January 7, 2002

RE: Highland Ave/Vermont Ave., Peaks Island, - 088-B-007 -- IR-1 zone

I am in receipt of your permit application to construct a single family dwelling in the vicinity of Highland Avenue and Vermont Avenue (088-B-007) on Peaks Island. Your permit is being denied for the following reasons.

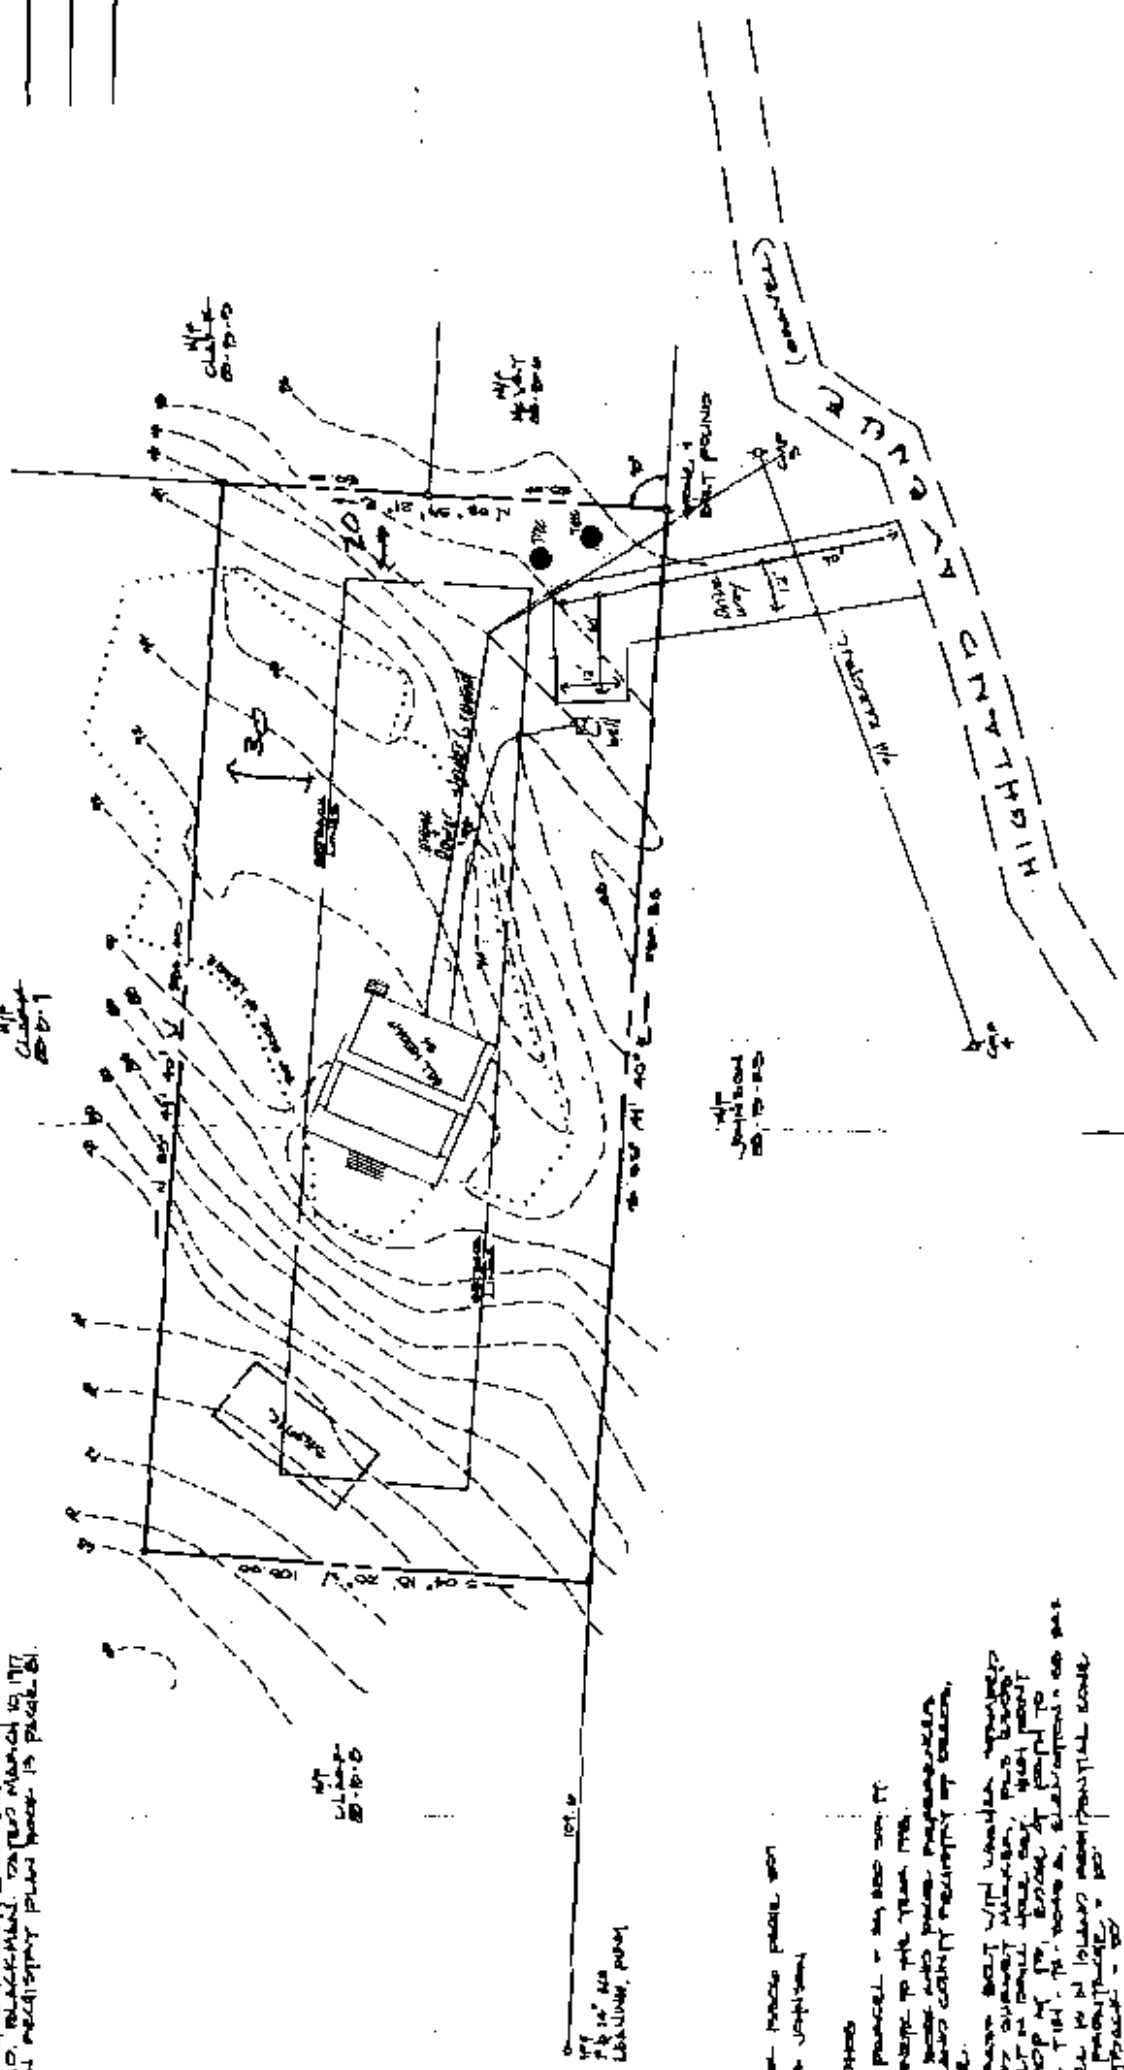
This property is located with in an IR-1 zone which requires a minimum lot area of 60,000 square feet of land area for properties without public water, section 14-145.5(a)1. You are showing a private well on this property and no access to public water. Your survey shows that you only have 26,280 square feet of land area which is less than the required land area. It is also apparent that this lot could not be considered a lot of record. By definition, a lot of record in this zone (IR-1), shall be held under separate and distinct ownership from adjacent lots since July 15, 1985, and meeting the applicable street frontage requirements of that time. Your submitted survey plan shows that you currently own an adjoining lot under the same name.

It is also noted that section 14-145.5(b) requires 100 feet of road frontage. Your submittal shows that this property has no road frontage at all, and therefore in violation of the IR-1 requirements.
